From: Simon Davis
Sent: 26 November 2018 10:49
Subject: P/107/18/DOC 7 Webb Close

Ecology comment (condition 14)

Drainage comment (condition 3)

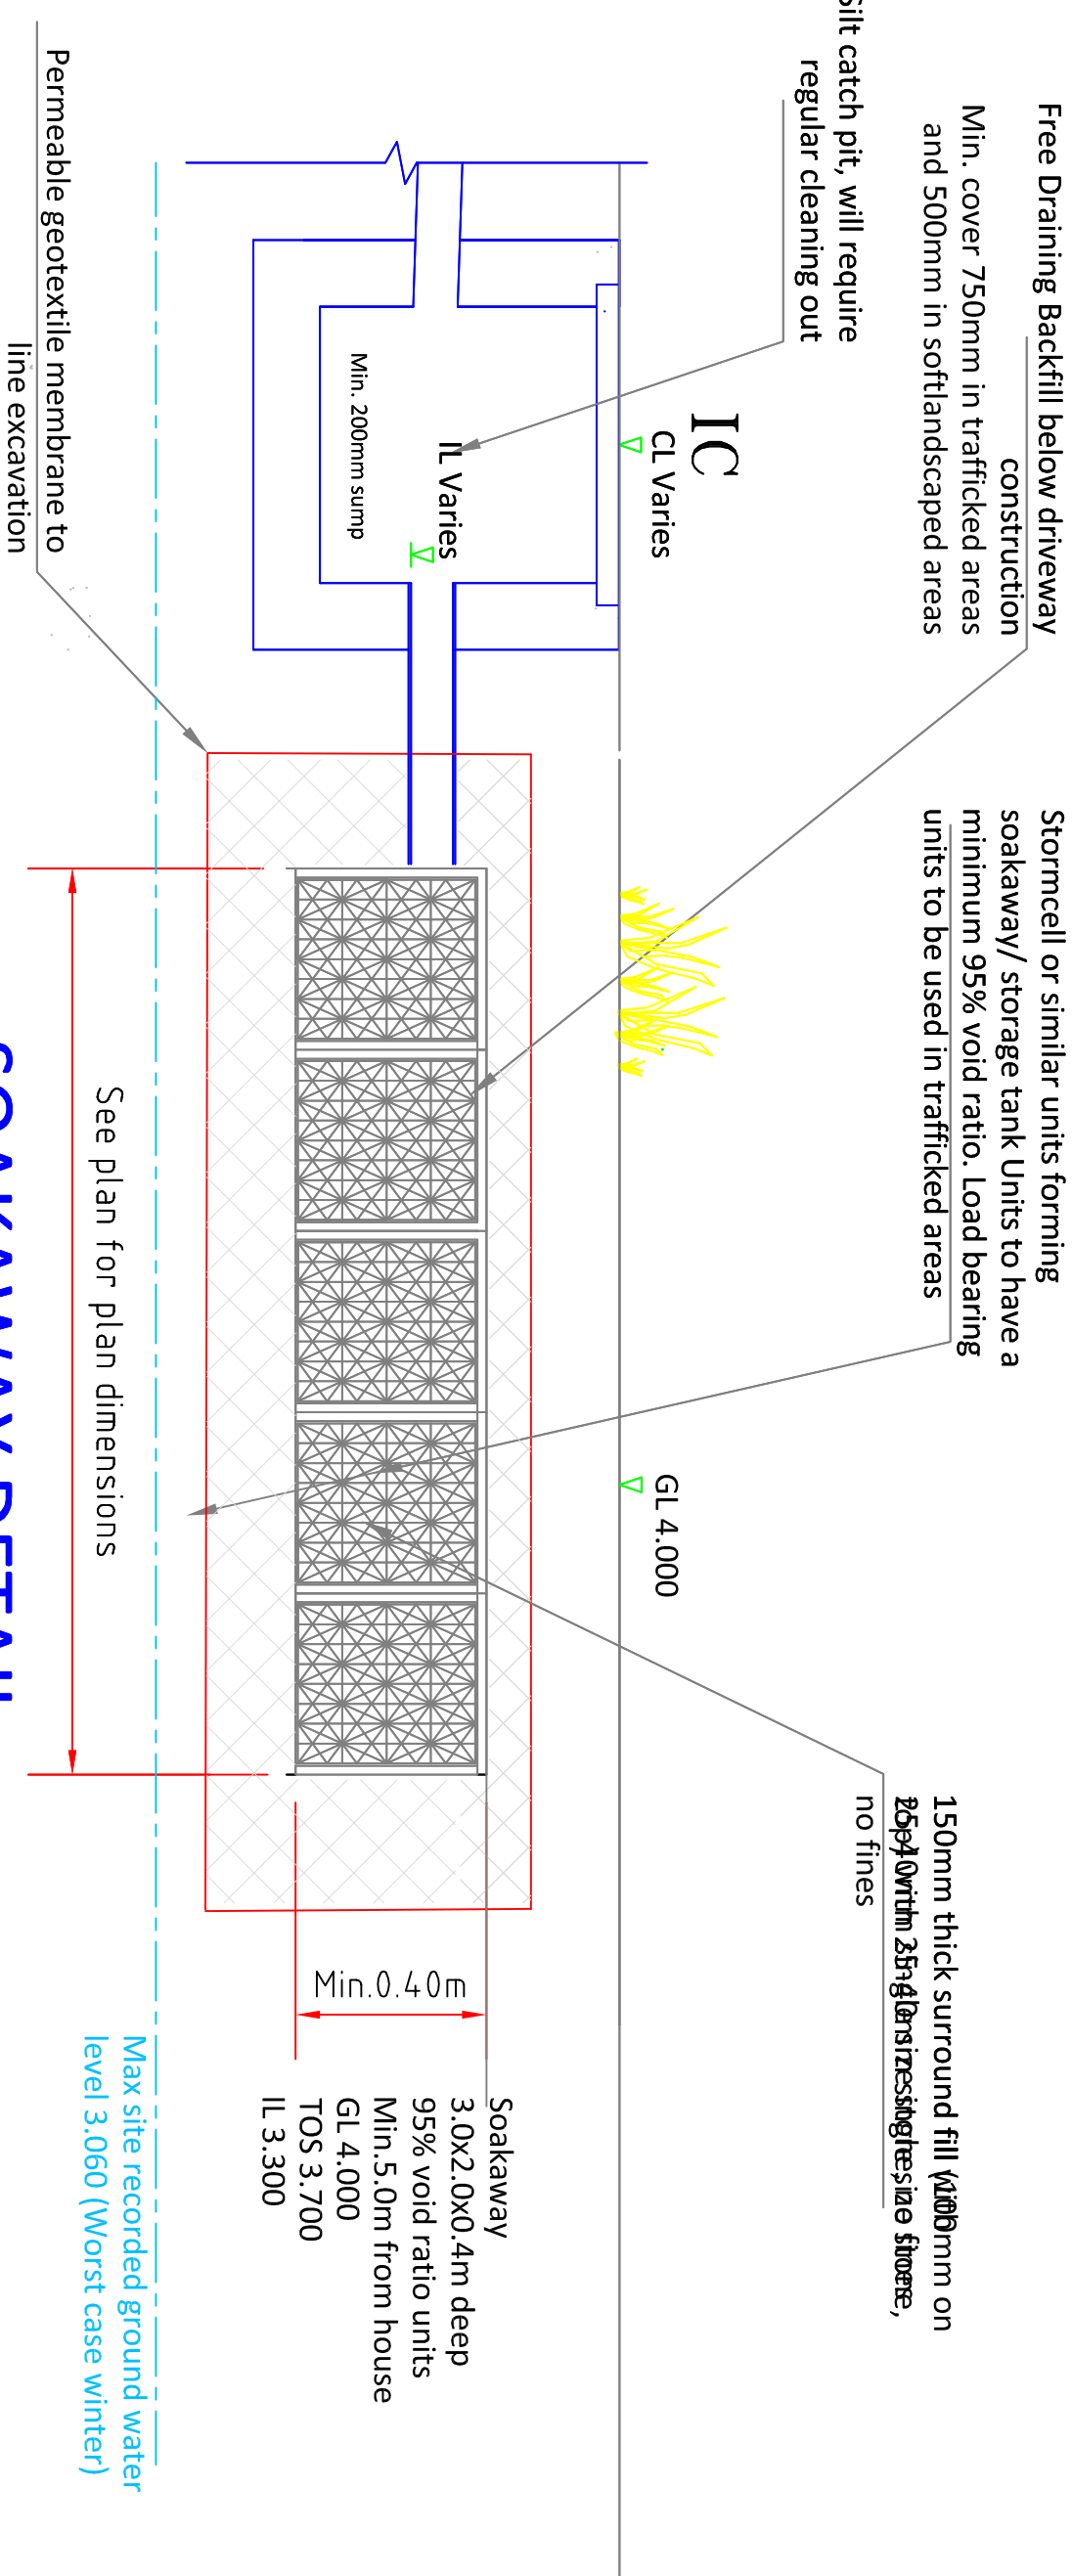
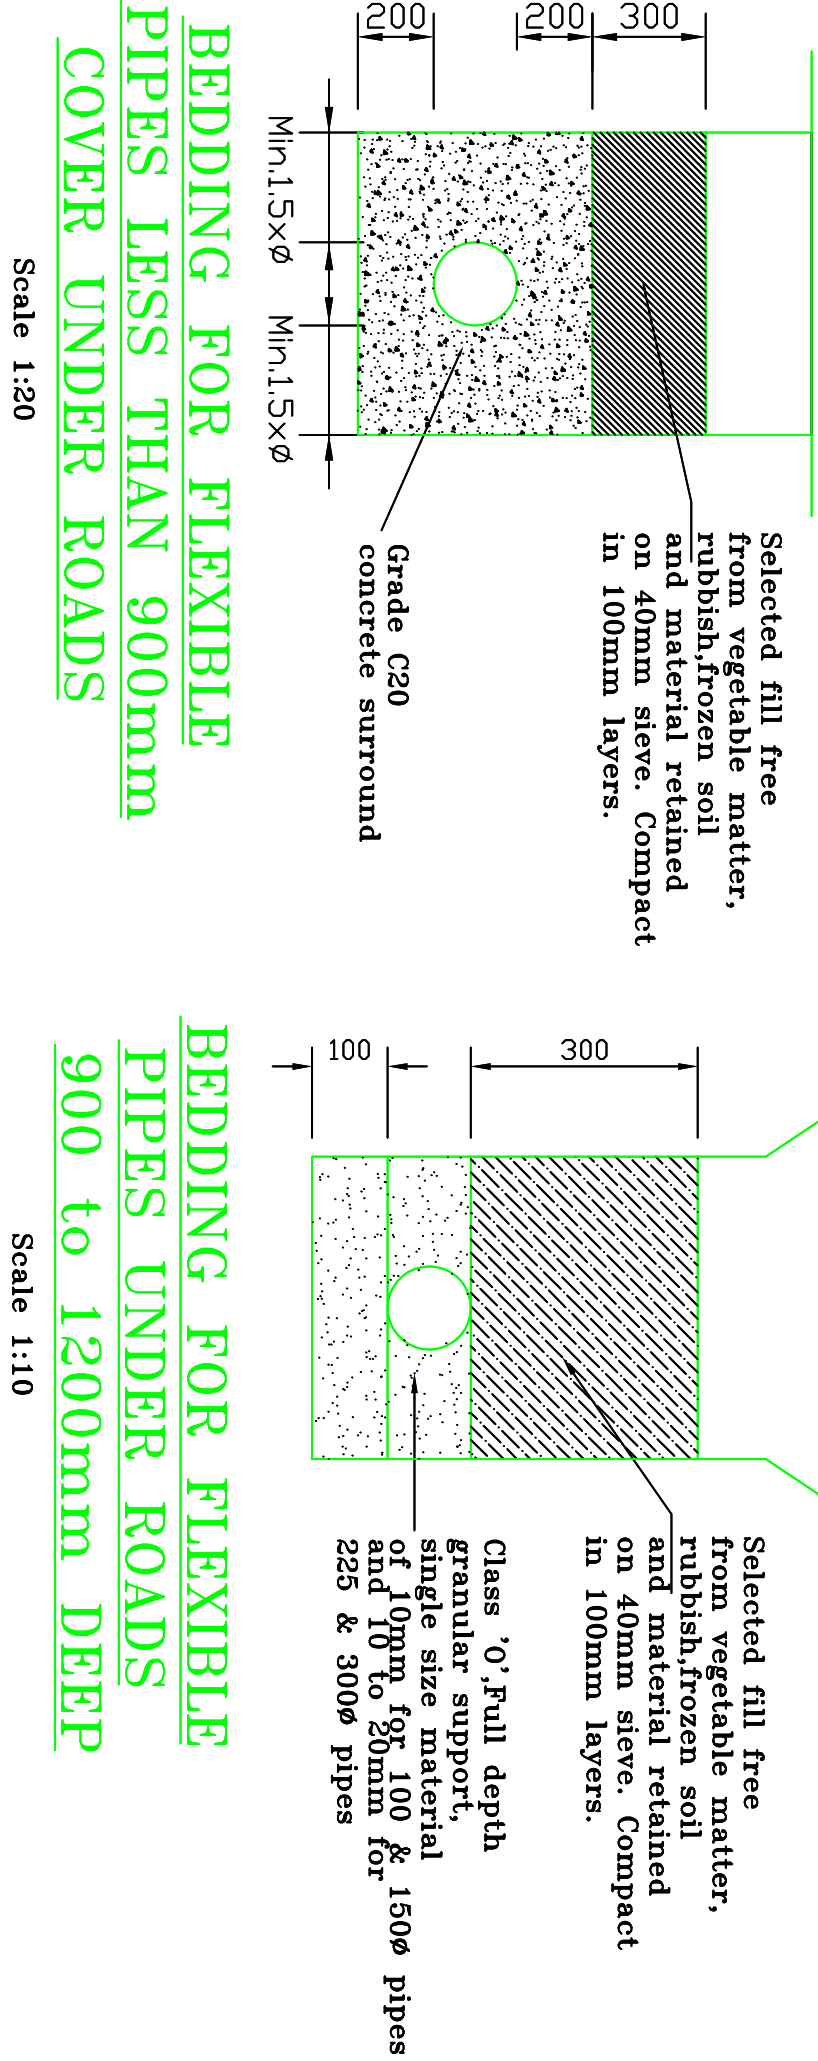
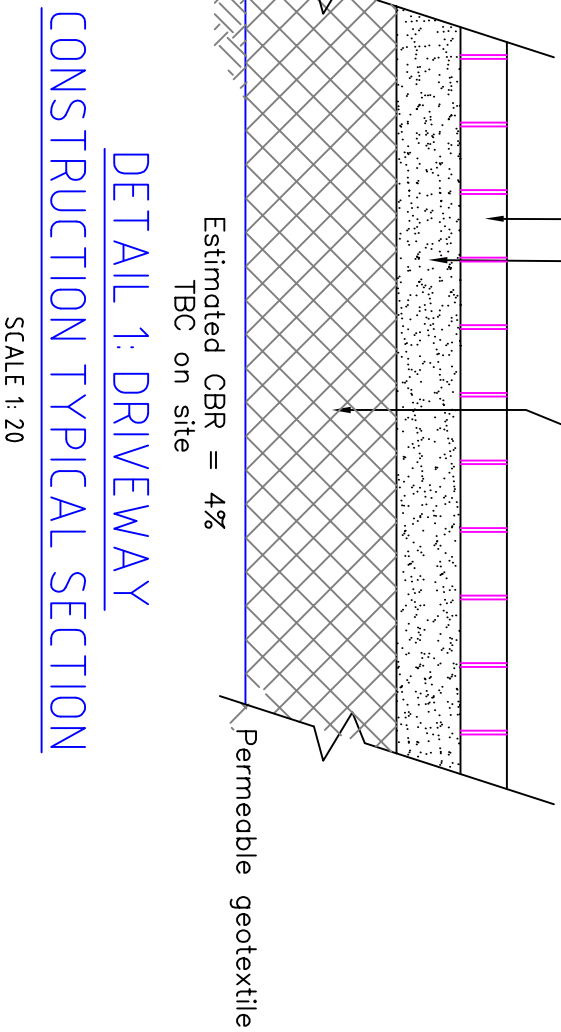
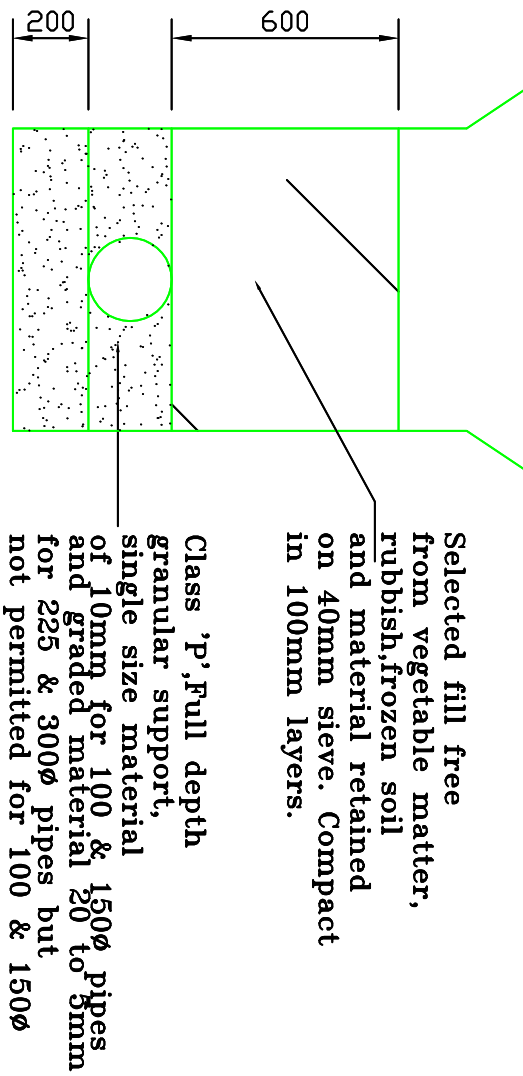
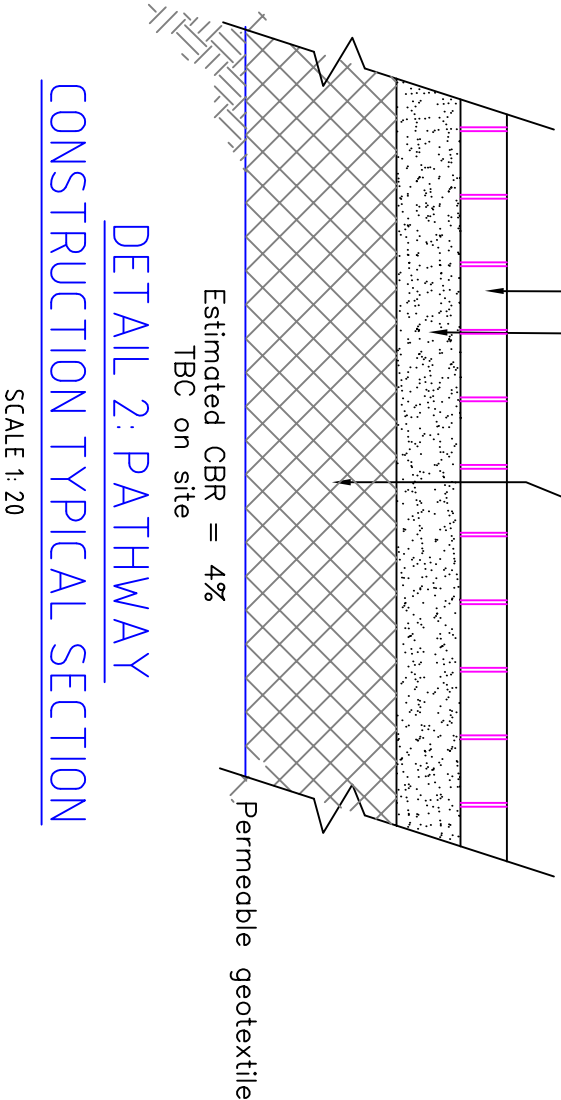
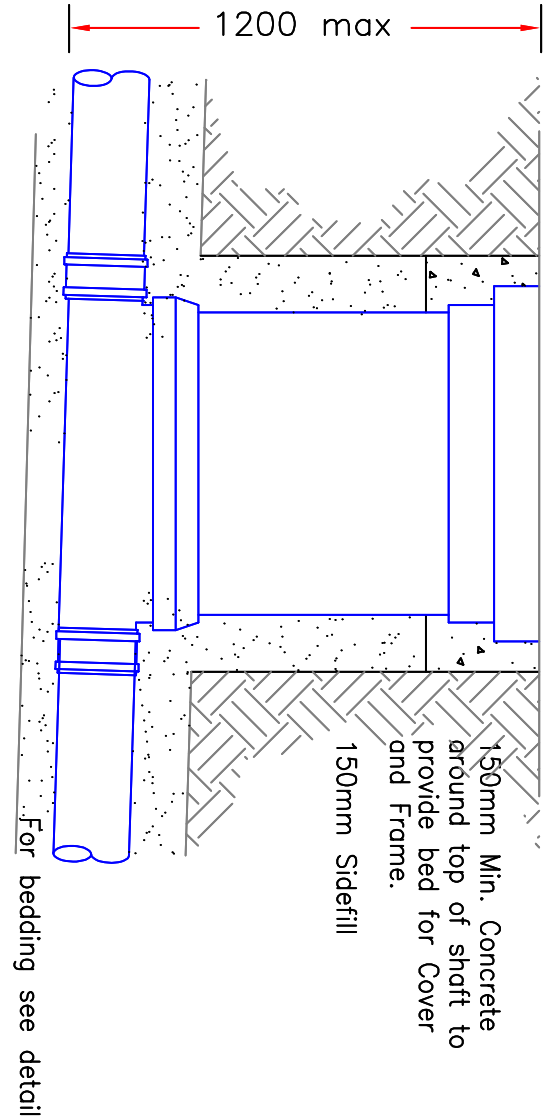
"The construction detail drawings provided demonstrate that there is an issue with the surface water drainage design. The soakaway crates proposed require a cover depth of 500mm in soft landscaped areas and 750mm in trafficked areas. Yet only 0.3m cover depth is proposed. Please specify stronger crates or alternative cover arrangements."

Biard Le Mans Up or Down Outdoor Wall Light

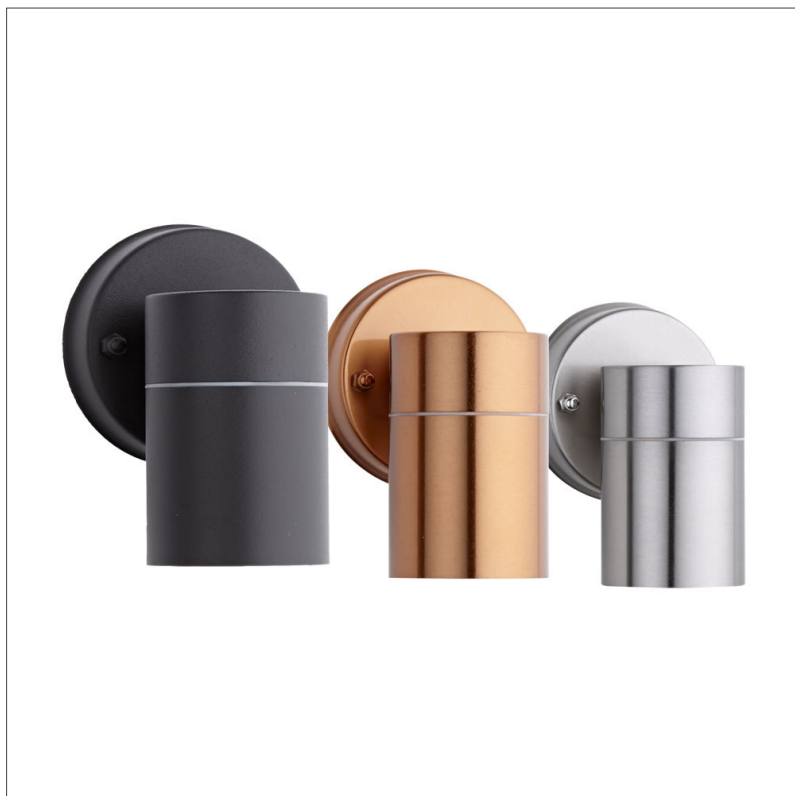
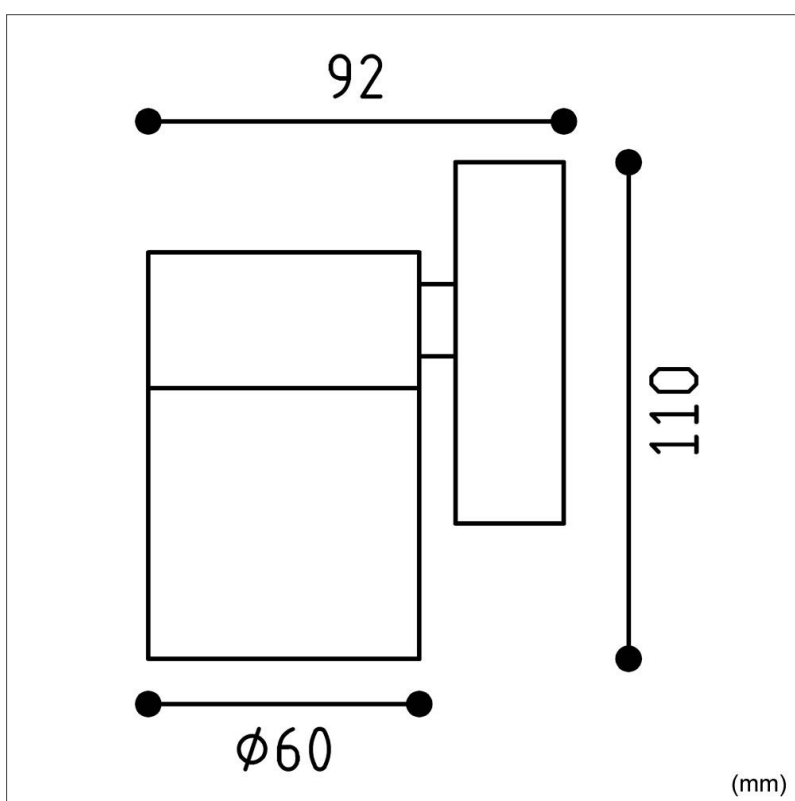
"The lighting details which have been provide include lights which can be used for up or down directional lighting. We require that only down lighting is used for the scheme, so the lights will need to be installed to only provide downward lighting."
